**New Public School at Mulgoa Rise, Glenmore Park (SSD 11070211)
EPA Advice on Environmental Impact Statement (EIS)**

The EPA has reviewed the document *New Primary School in Mulgoa Rise Review of Environmental Factors – Noise & Vibration Assessment Report*, Rev 2.0, dated 12 August 2021, prepared by Pulse White Noise Acoustics (the NVA), and provides the following comments and recommendations.

Figure 12 Building envelope recommendations – Building C, Communal Hall

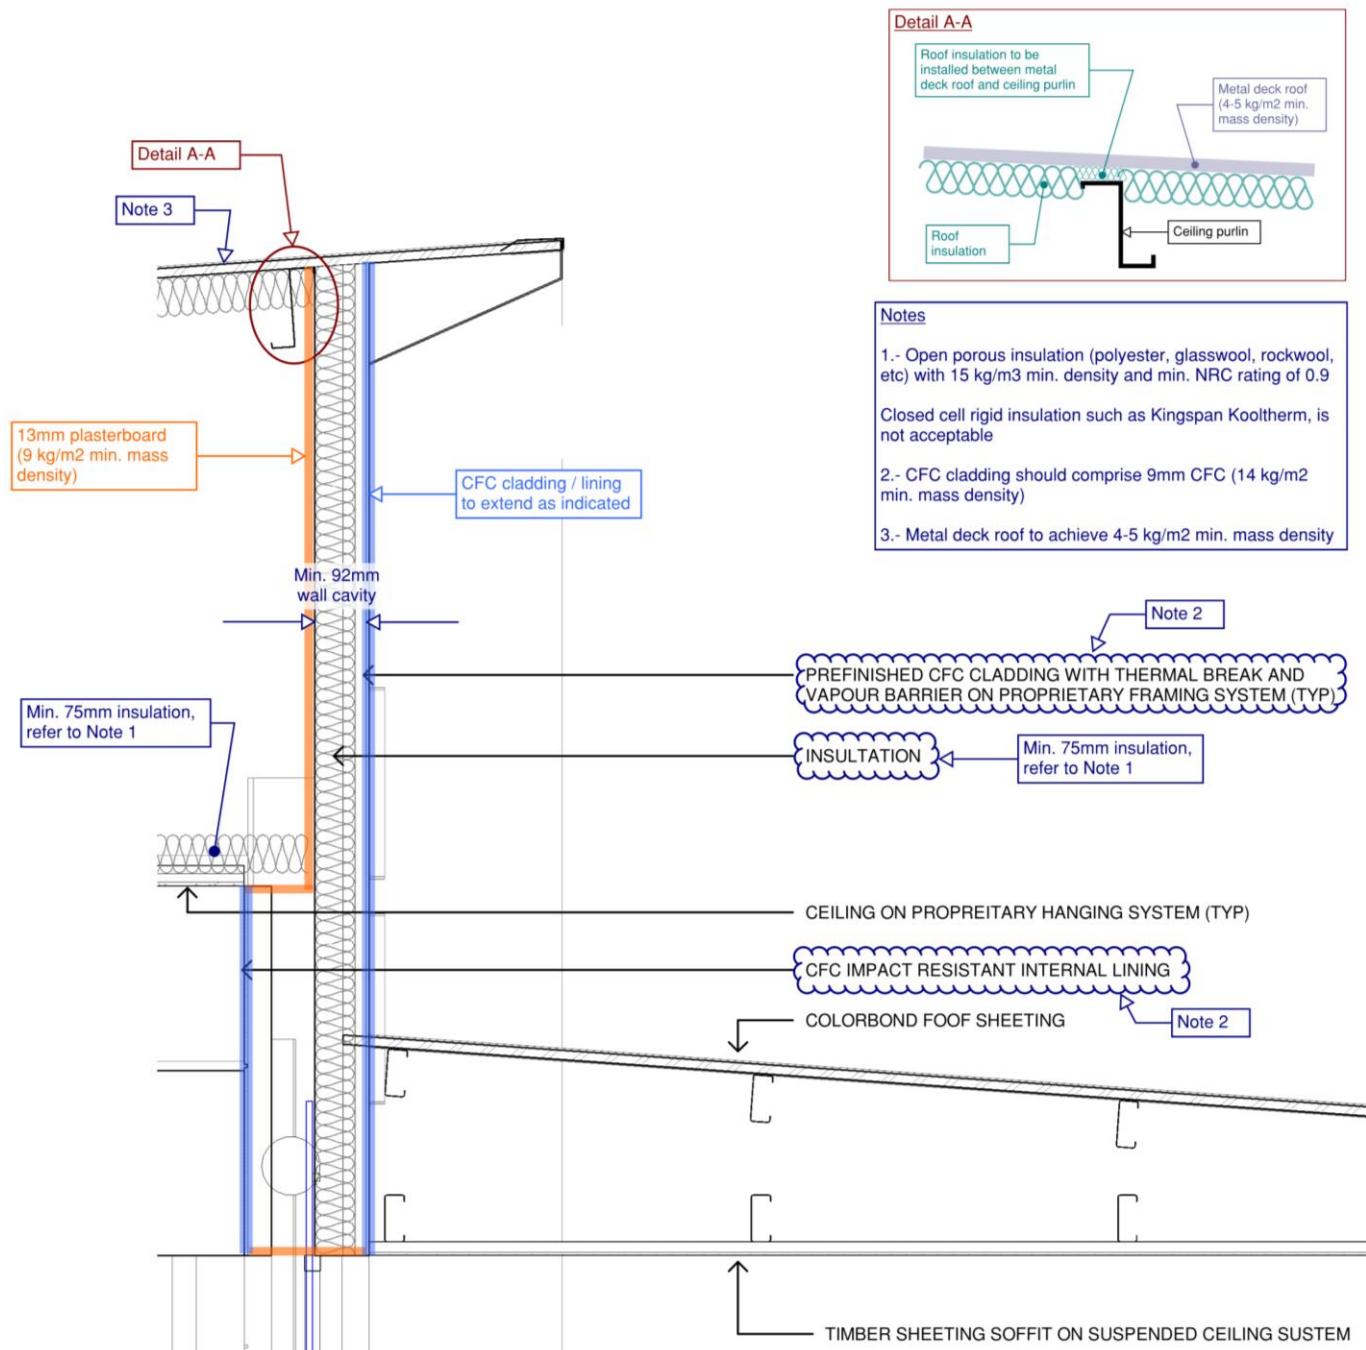
The EPA recommends the development consent include a requirement to restrict usage of the School Hall to appropriate activities, and appropriate times, so that noise does not unacceptably impact on surrounding residents.

The NVA states in Section 1.1 "*It is intended that the Communal Hall in Building C, and library in Building A; operate between 6:30 pm and 10:00 pm as part of the out of hours operation. On rare occasions, these out of hours activities could extend till 12:00 am.*" The NVA does not predict noise levels for School Hall Out Of School Hours (SHOOSH) operations, it only states operational procedures if activities occur out of school hours (such as closing all external doors and windows). The EPA considers, in relation to the School Hall, that noise from normal activities would not be acoustically significant.
